Department of Transportation

RE: Waterbury Filings Nos.1 and 2 PUD PP - PUDSP215

The Master Development Drainage Plan & Preliminary Drainage Report for Waterbury Filings No. 1 & 2 dated March 2022 and the Grading, Erosion & Sediment Control Plan for Waterbury Filings No. 1 & 2 dated July 20, 2022 have been reviewed by a CDOT Hydraulics Engineer. Their comments follow:

EAST CONCRETE FOREBAY/MICROPOOL DETAILS
SCALE: 1"=10'

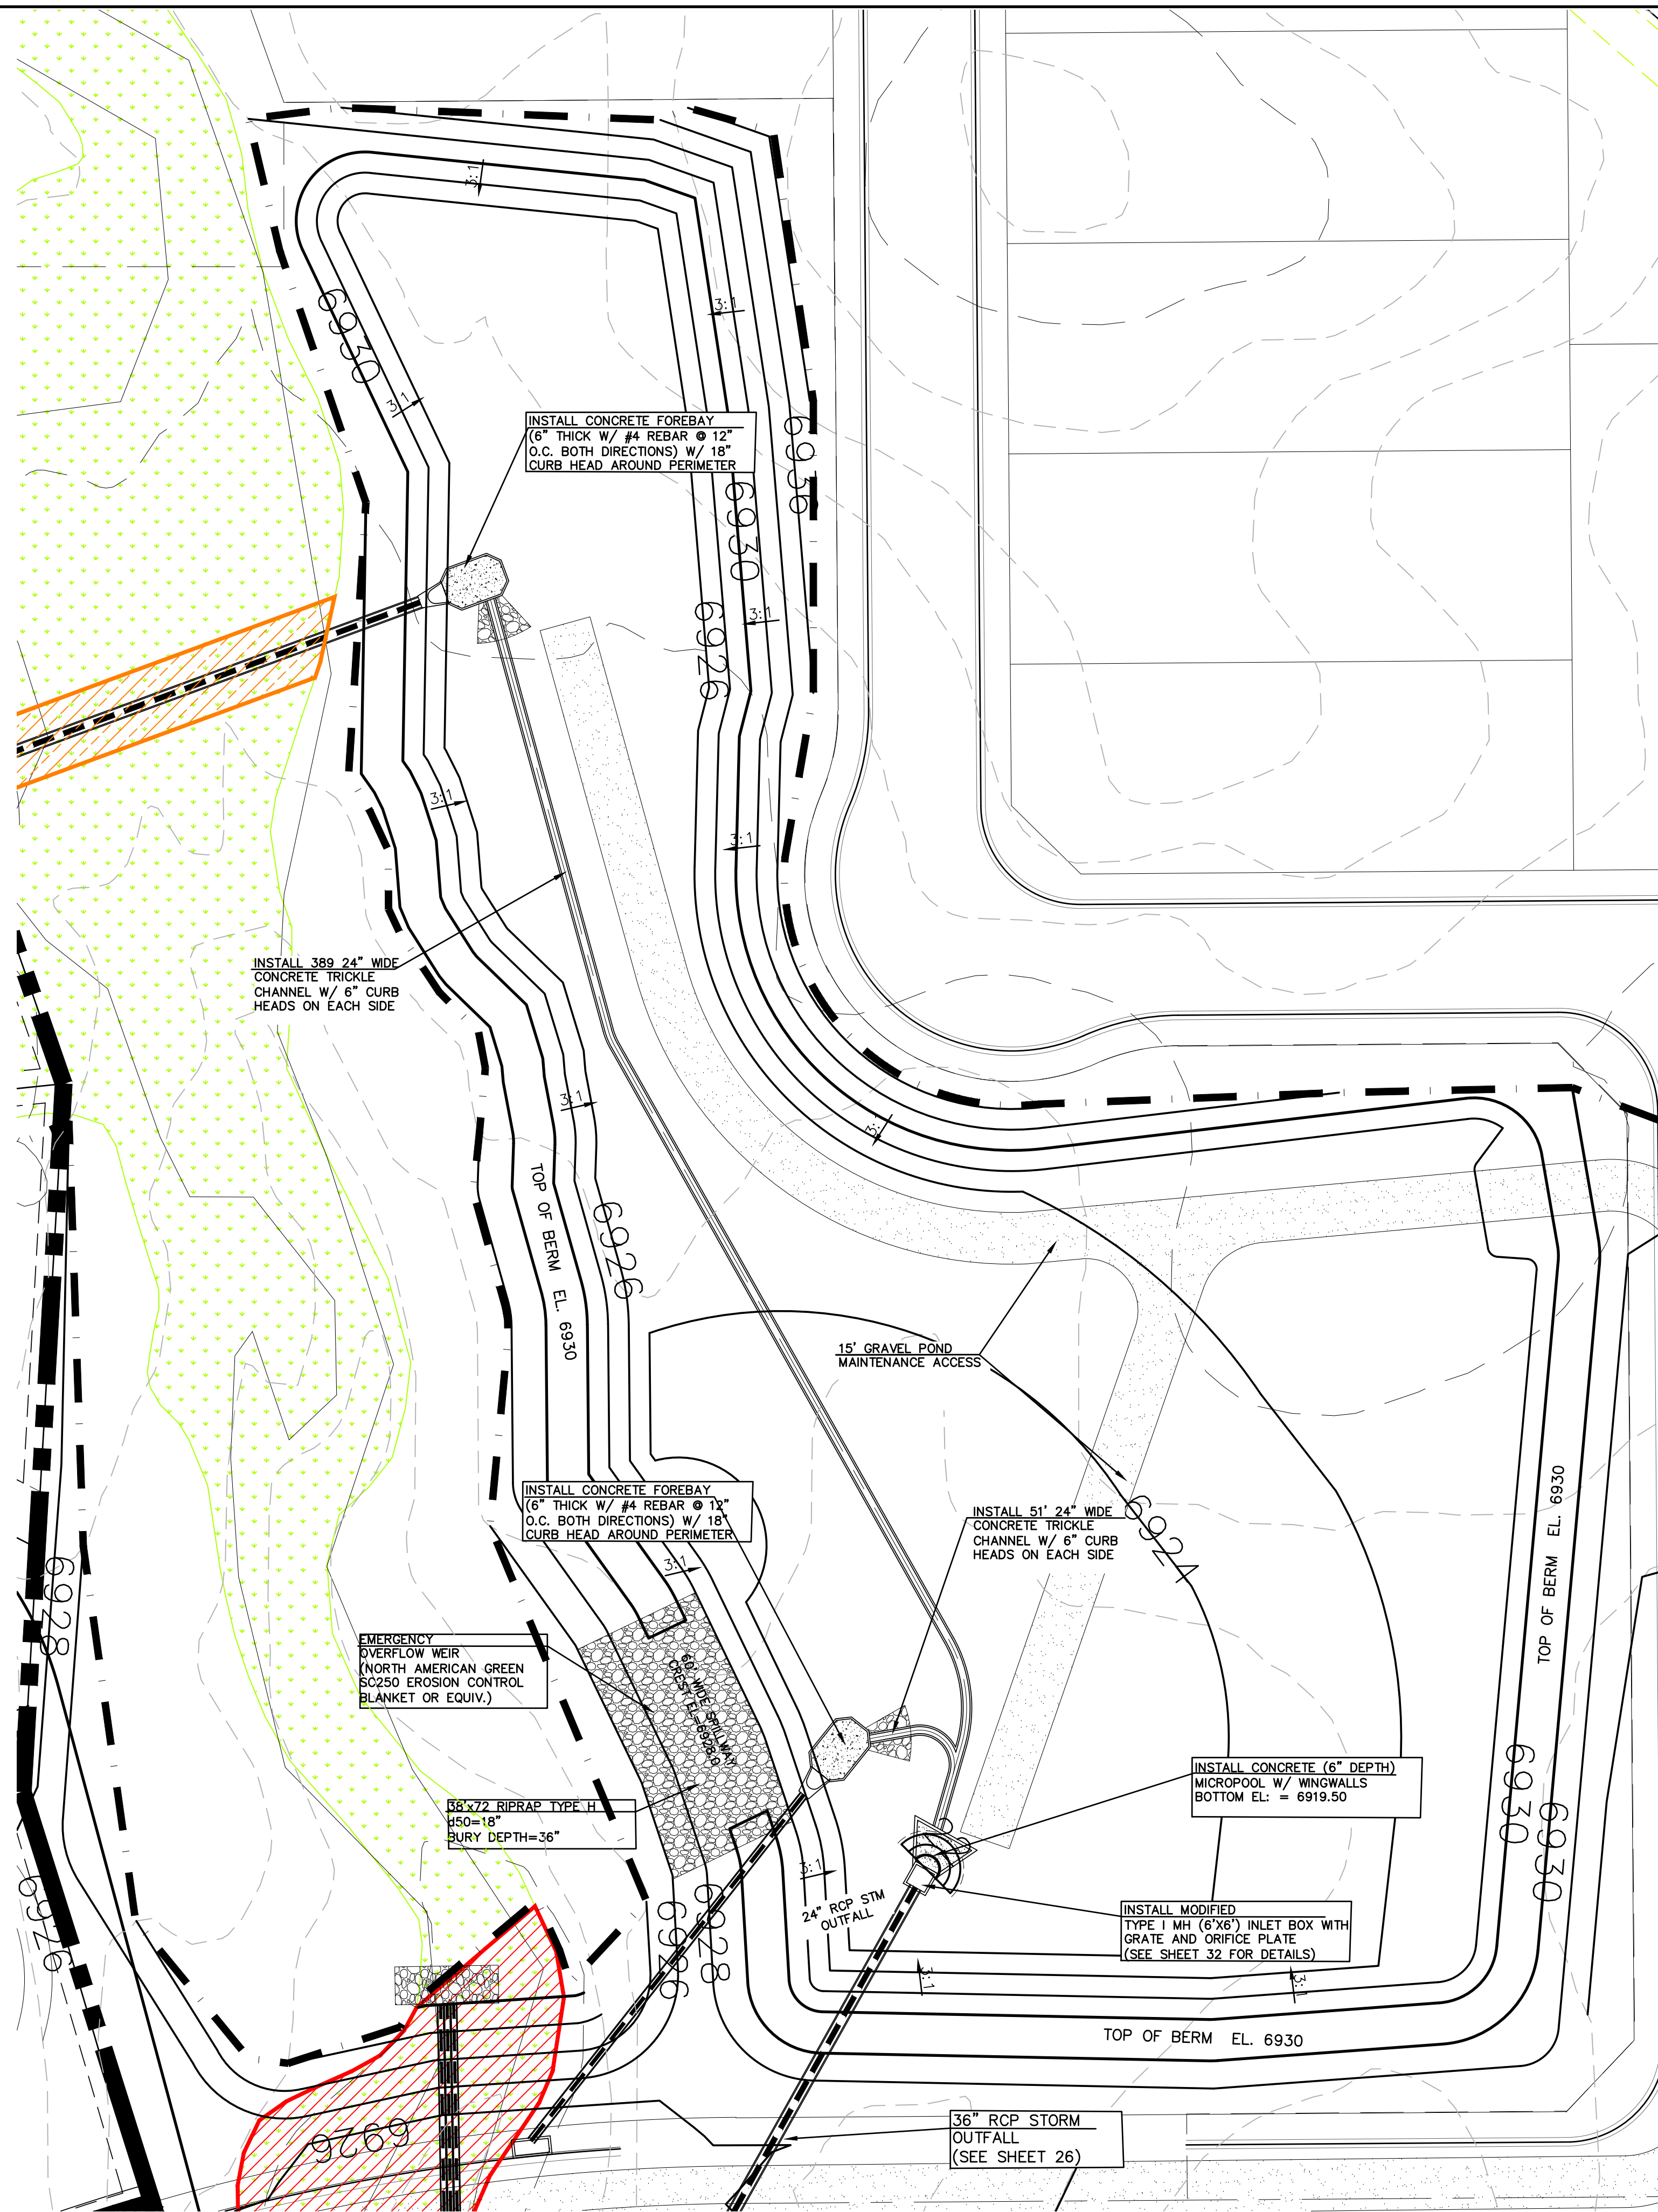
- Note: The construction set was not resubmitted in this submittal. The construction set from the previous submittal (October 2021) was reviewed and compared to the inputs in the H&H calculations.
- Basin forebays are located concerningly close to the outlets. Consider revising the layout of the detention basins to prevent short-circuiting the basin. Refer to the CDOT Drainage Criteria Manual (DDM) Chapters 12 and 16 for further guidance.

- Pond 3 ratio of peak outflow to predevelopment Q is greater than 1.0 for the 10-year event. (Page 187 of the drainage report)
- There are duplicate items in the appendix (drainage maps and HECRAS profiles).
